Application for Planning Permission for Works or Extension to a Dwelling

Development: Single storey front porch and rear extension, conversion of integral garage to habitable use, extension to detached garage and alterations to fenestration/openings.

Location: The Bungalow Nyton Road Westergate PO20 3UQ

EXISTING NORTH ELEVATION

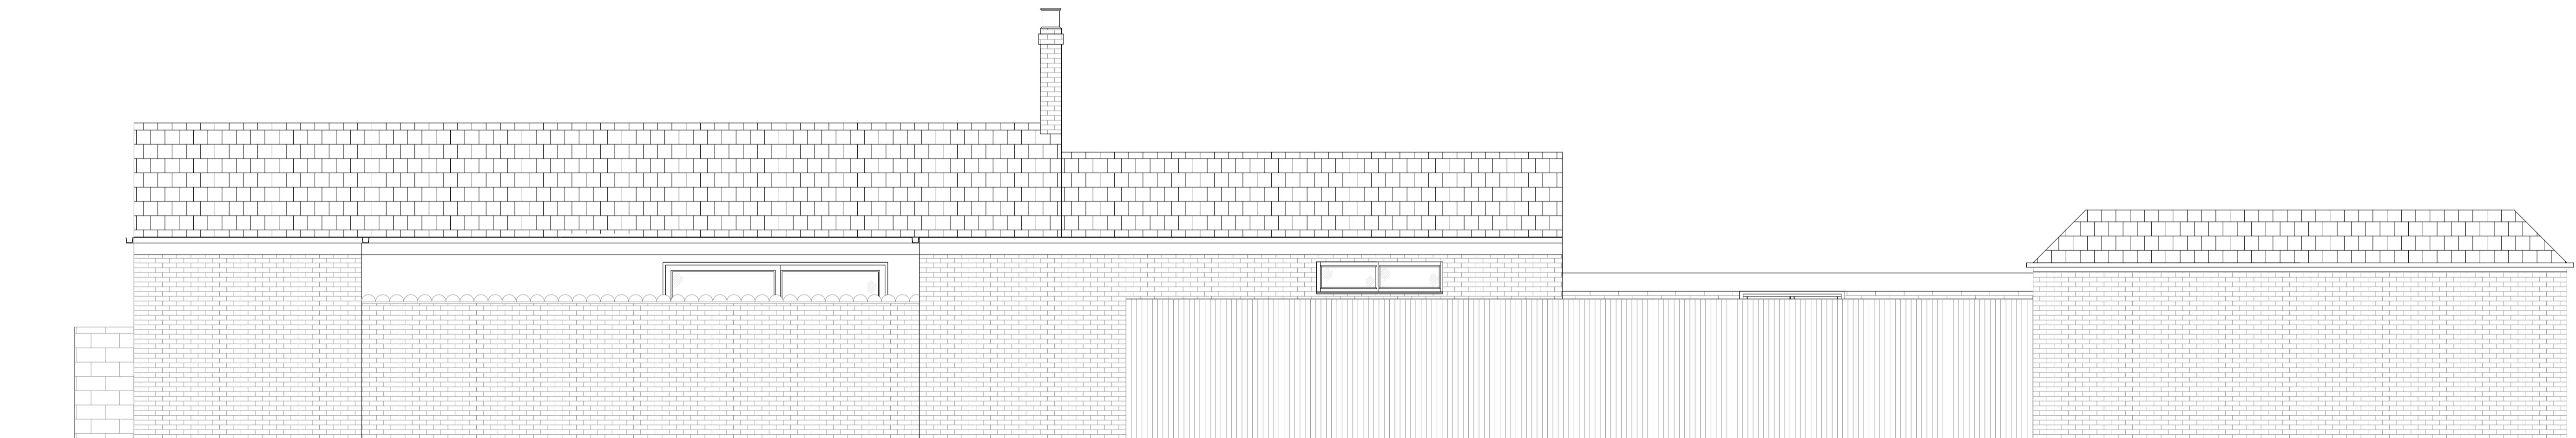
Please submit the north elevations without the fence obstructing the view. Further details can be found in the Validation Requirements List.

EXISTING SOUTH ELEVATION

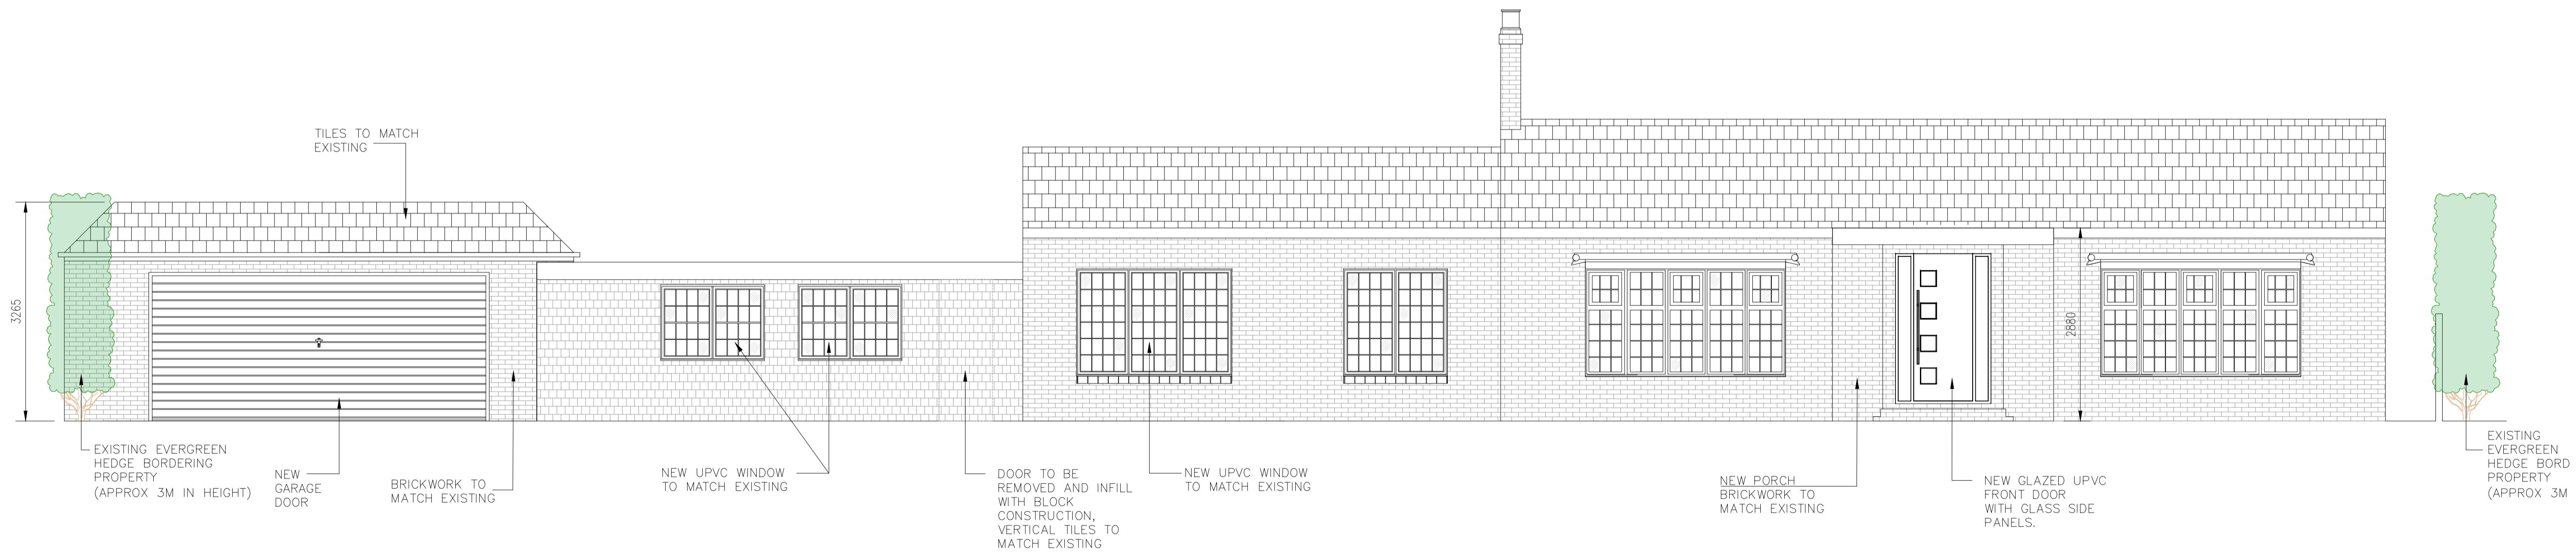
The existing south elevation is inconsistent with the existing ground floor plan, please review and amend.
